KITTITAS COUNTY

MEMORANDUM

TO: Jeff Watson, Planner II
FROM: Christina Wollman, Planner III *CW*
DATE: October 13, 2015
SUBJECT: Request More Information
Filbert Estates Short Plat SP-15-00004

KITTITAS COUNTY	WASHINGTON
DWN BY	DATE
G. WEISER	09/2015
CHKD BY	SCALE
D. PIERCE	1"=200'
JOB NO.	SHEET
15091	1 OF 3

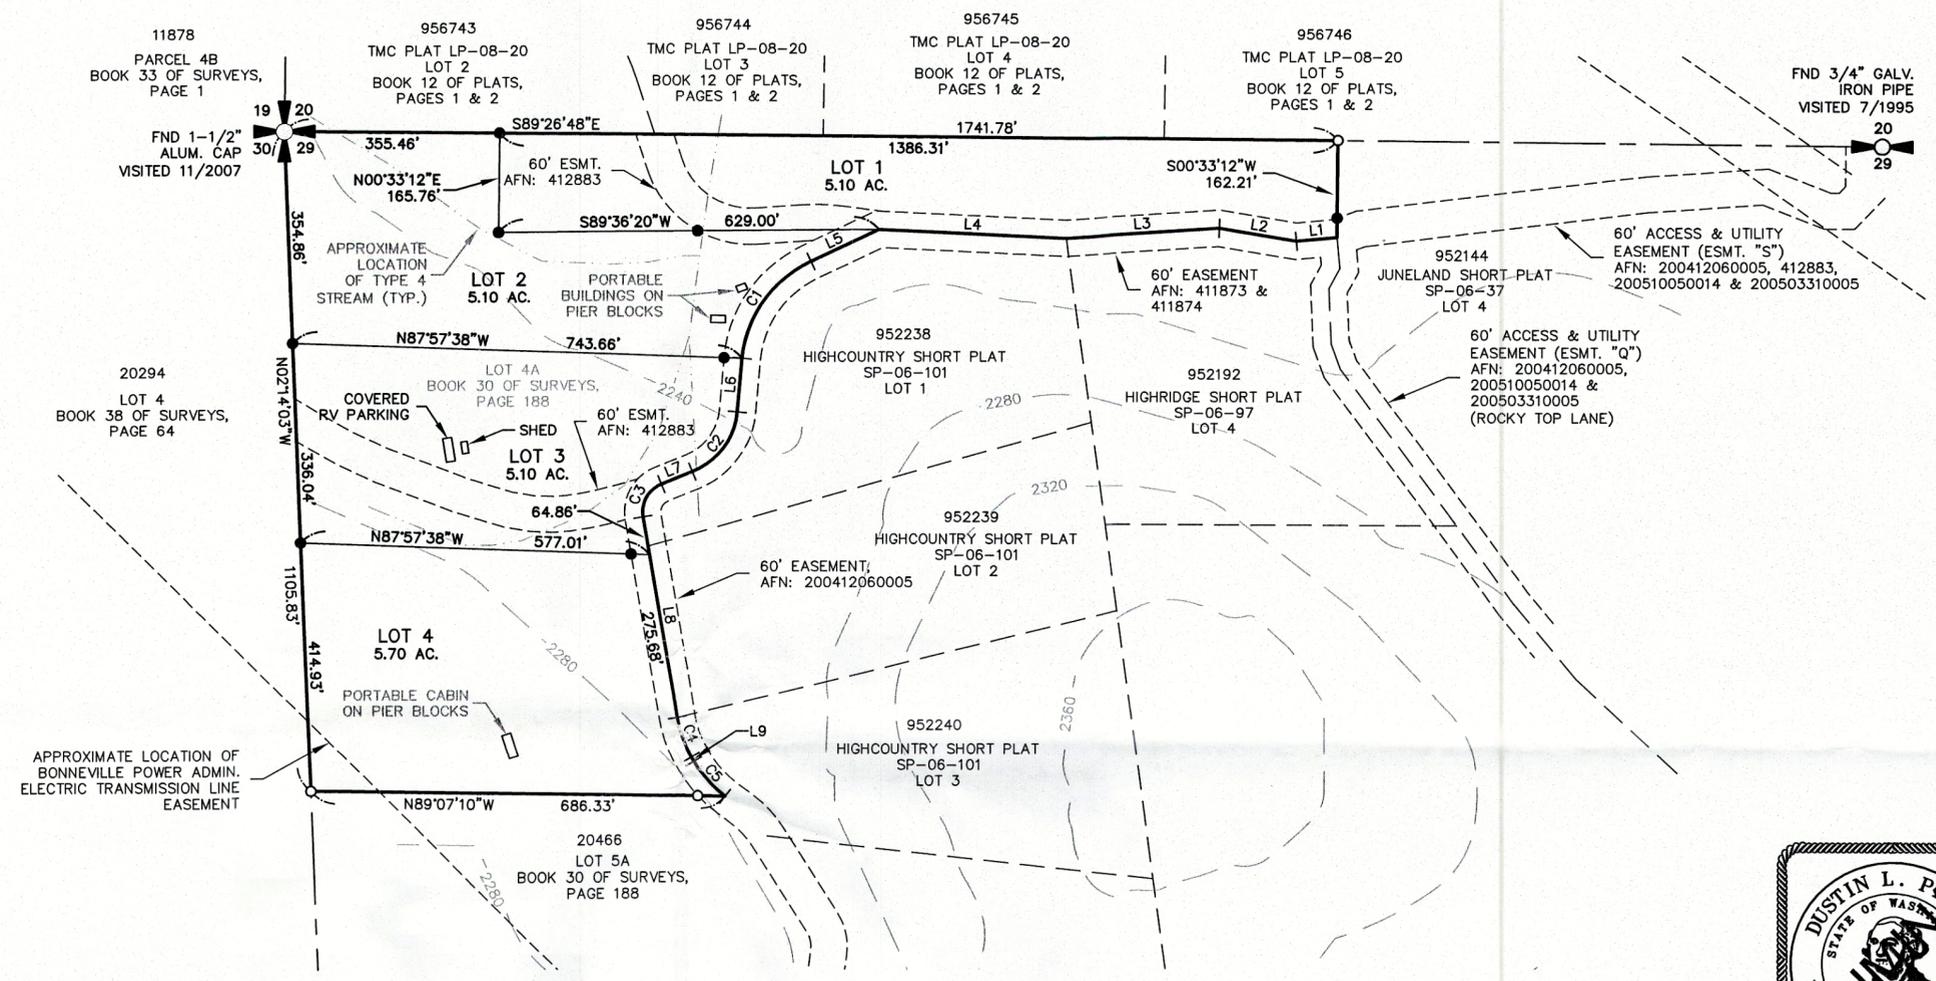
The existing bridge over the canal must meet the guidelines of KCC 12.07.010 and 12.07.030. The bridge must be the same width as the private road, which will have a width requirement of 22'. The existing bridge appears to be approximately 14' wide. The applicant shall provide additional information on how they intent to meet this requirement. This information will be required prior to the issuance of conditional preliminary approval.
